**TEMPORARY CONSTRUCTION ACCESS
FORD LANE, YAPTON, WEST SUSSEX**

**DESIGNER'S RESPONSE TO ROAD
SAFETY AUDIT STAGE 1/2**

Report No.: 18-344-14

Date: October 2020

Scale 1:200 @A1	Date AUG 20	Designed
Drawn JA	Checked SG	Approved LH
Job No 18-344	Drawing No 18-344/703	Rev B

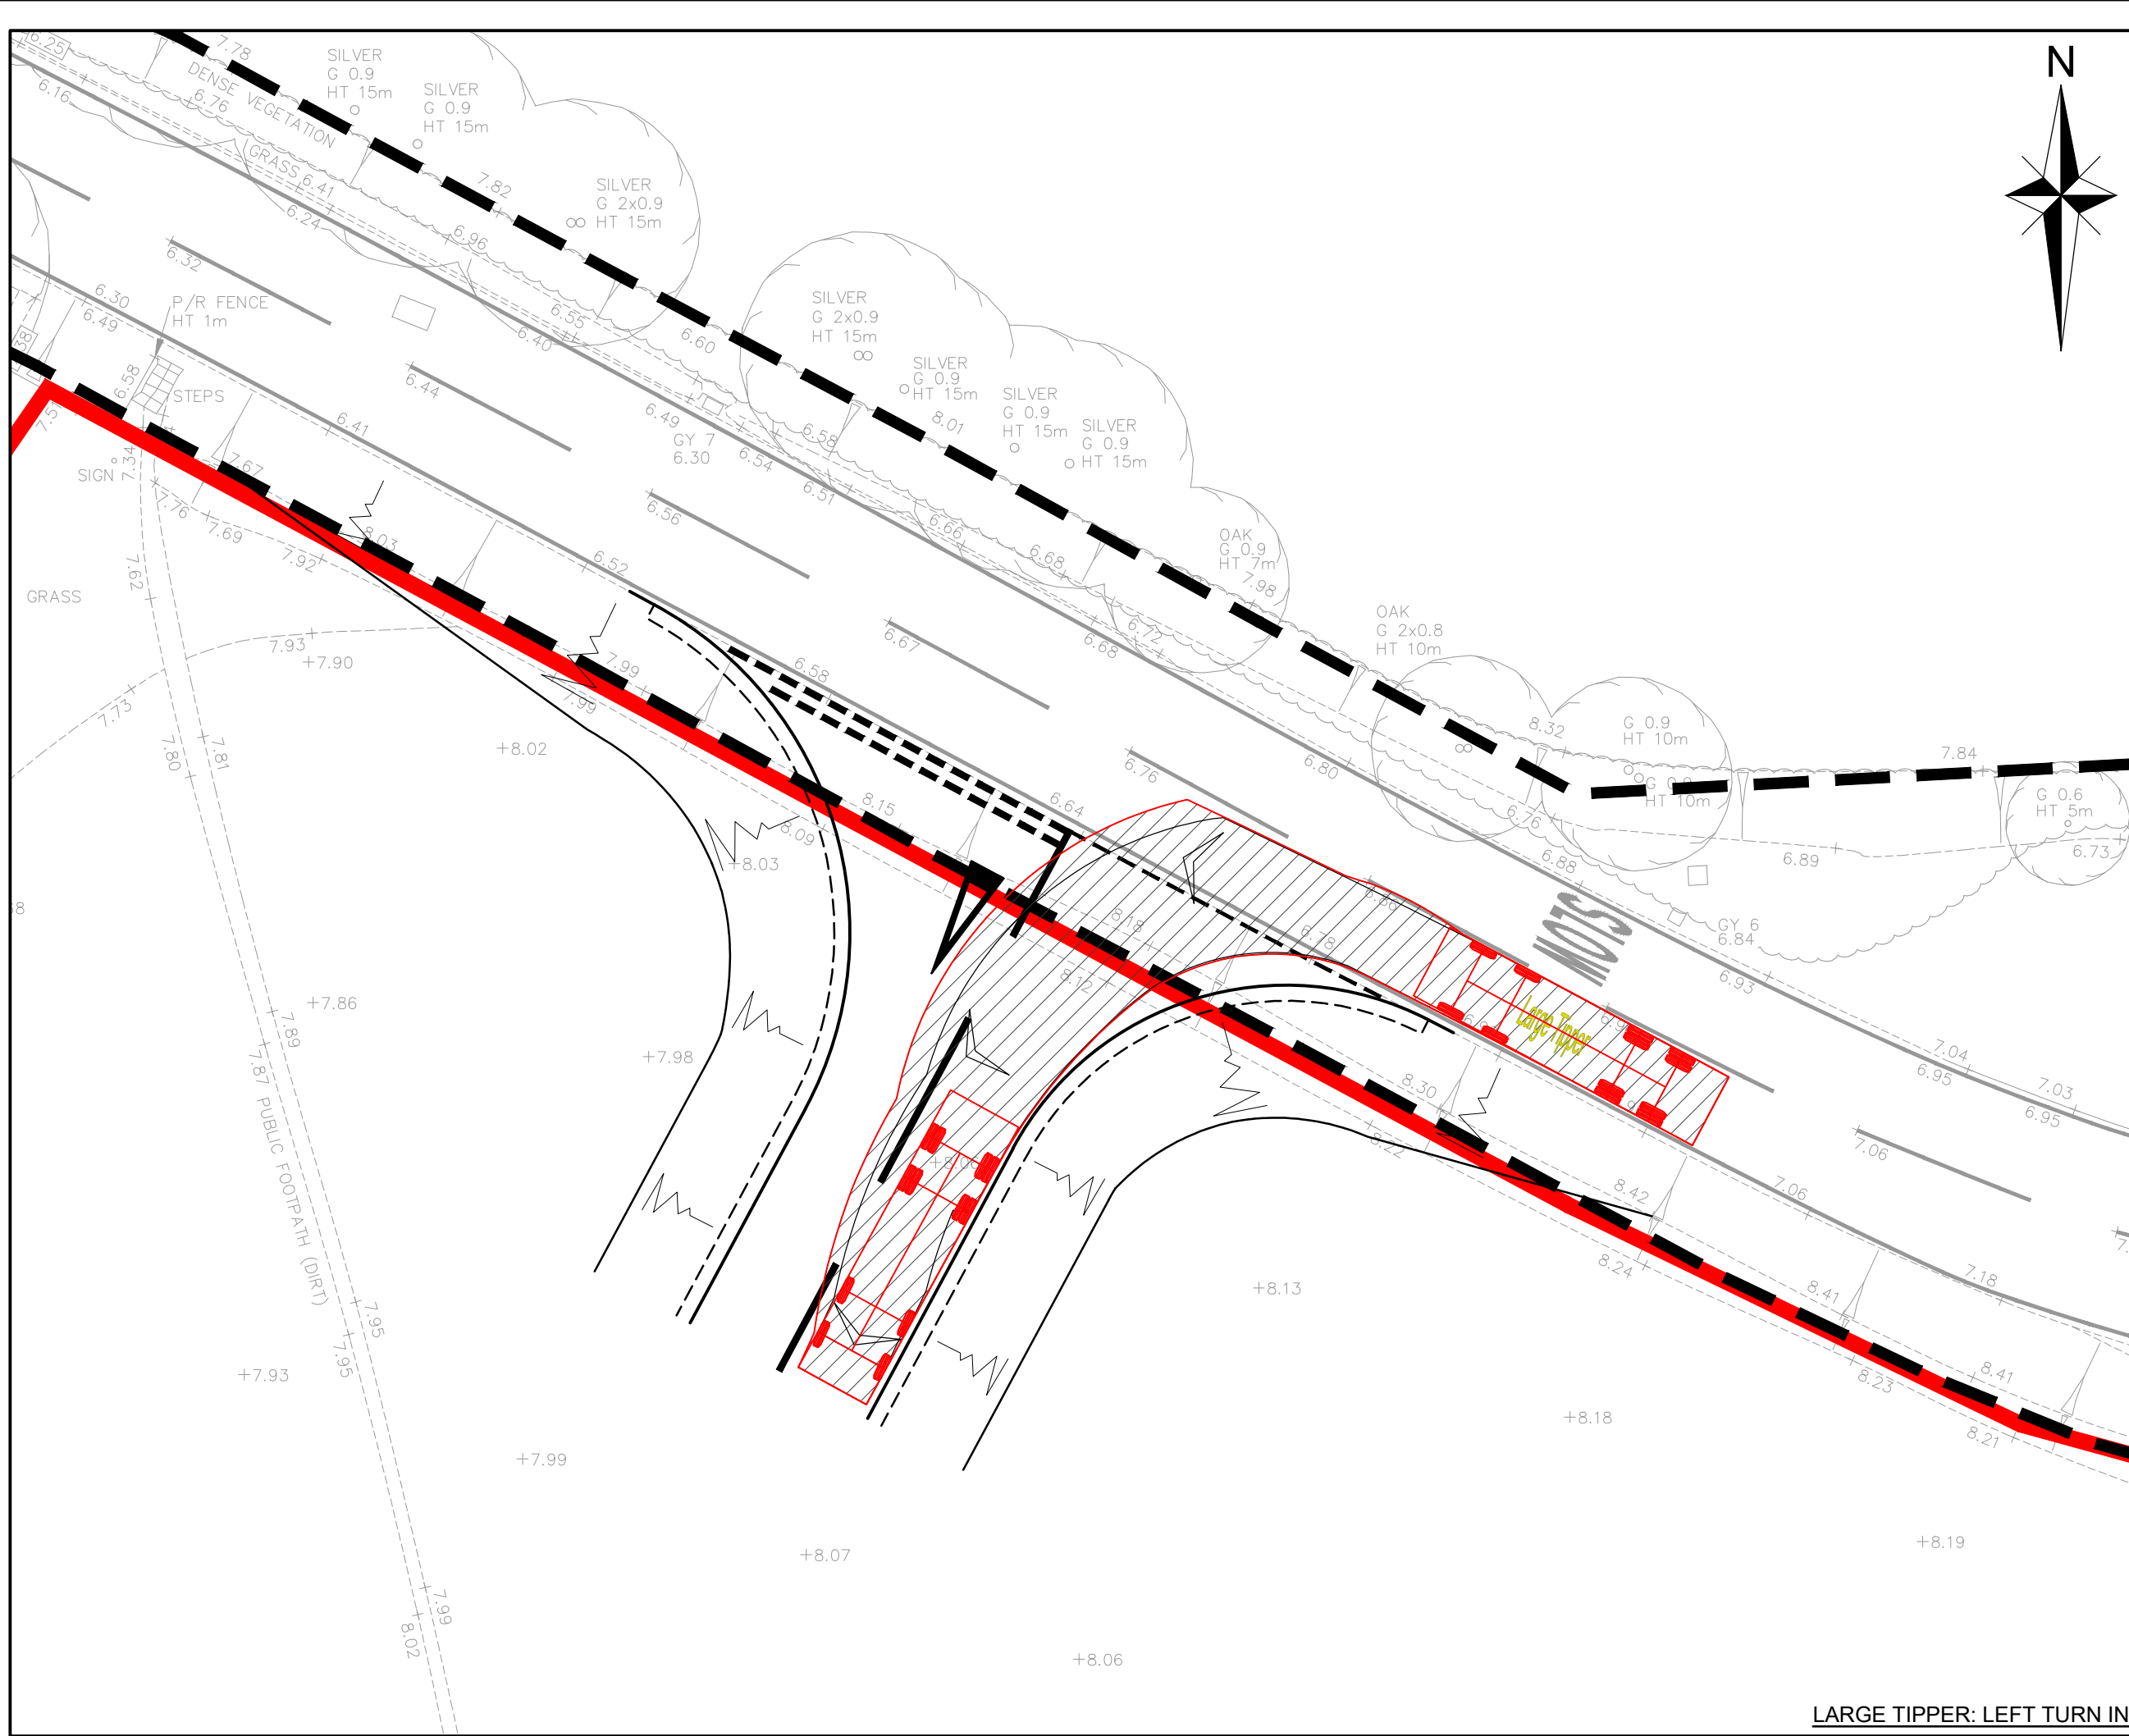
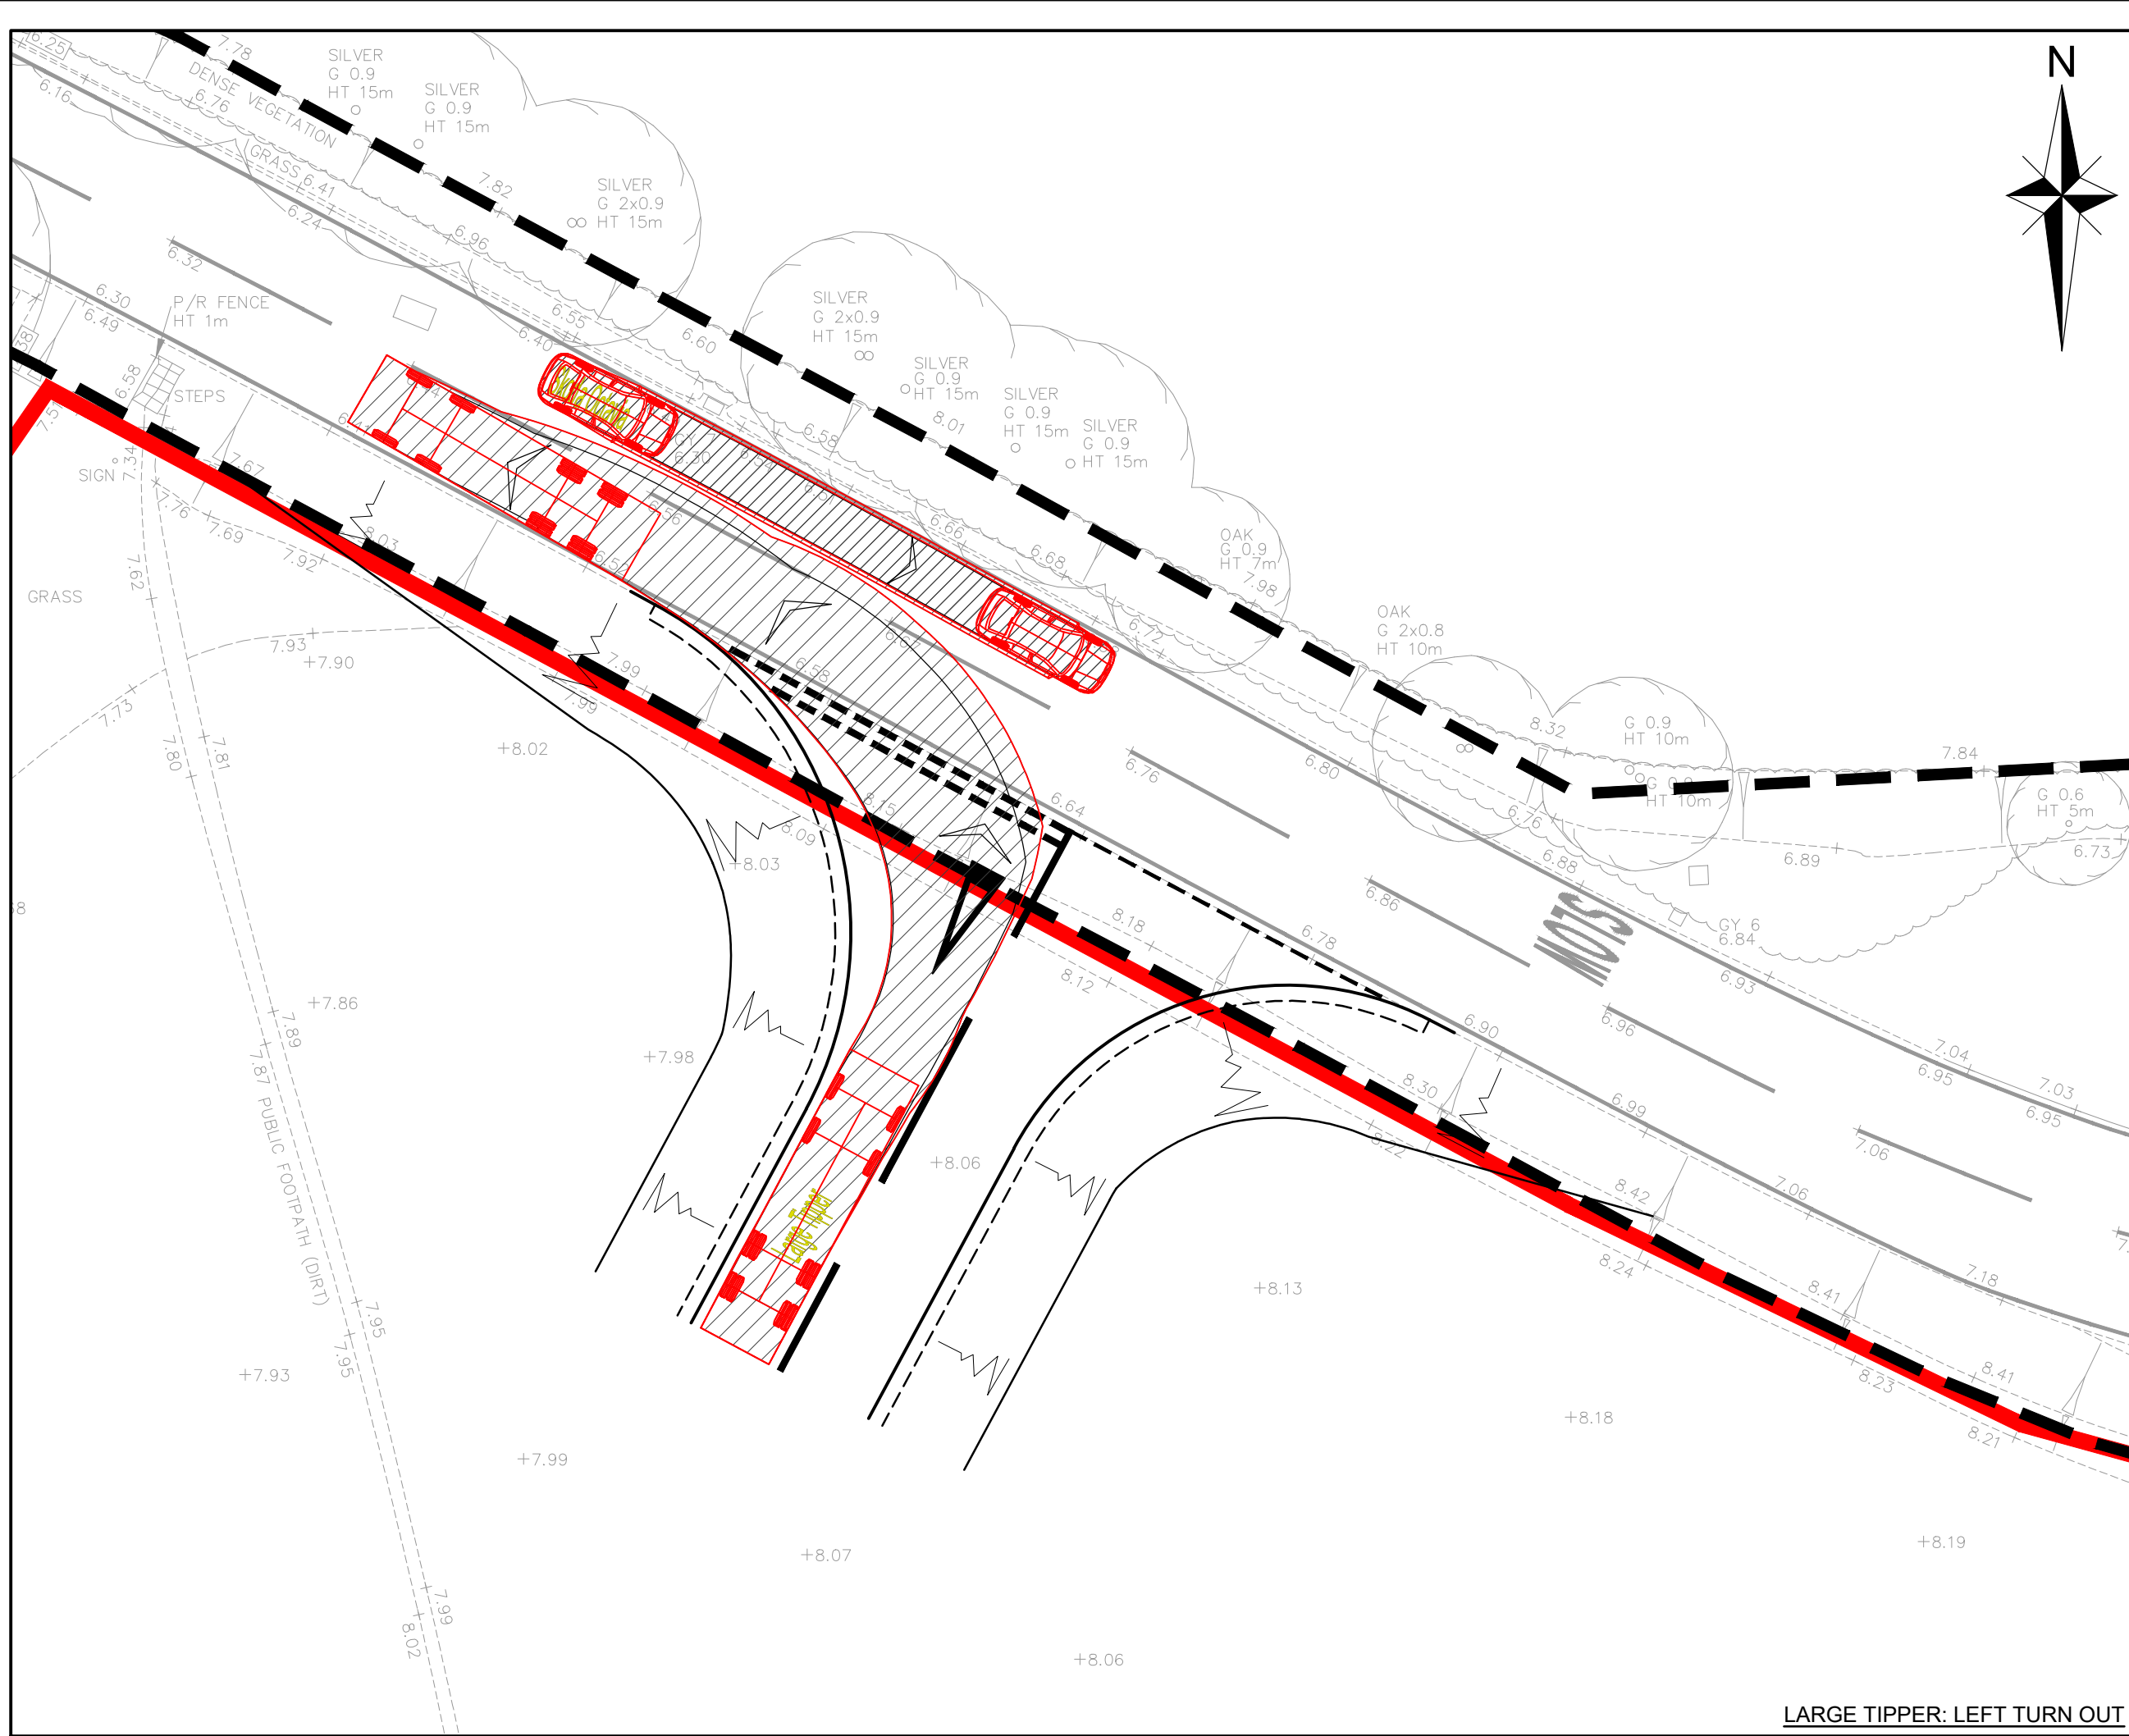
Audit Item No.	RSA Problem	RSA Recommendation	Design Organisation Response	Overseeing Organisation Response	Agreed RSA Action
3.2	LOCAL ALIGNMENT				
3.2.1	PROBLEM Location: At the proposed access. Summary: Insufficient carriageway space could lead to rear end shunt head on or side impact collisions. The proposed temporary access is shown as being 5.5m in width and has a 6m radius on the south eastern side of the junction. Swept paths provided show marked deviations in paths taken to make the turns into and out of the temporary access., which could lead to head on collisions. There is concern that at 5.5m in width with the current radii that two-way HGV operation of the access will not be possible.	It is recommended that the temporary access and associated radii should be capable of accommodating simultaneous two-way HGV movements.	The junction layout is typical for this type of access/use. Provision of a layout to simultaneously accommodate two HVGs would make the access unnecessarily oversized and could lead to increased vehicle entry/exit speeds.	Radii and width have been increased to accommodate 2 way HGV's	Access widened to 6.5m and junction radii increased to accommodate 2 way HGV's.
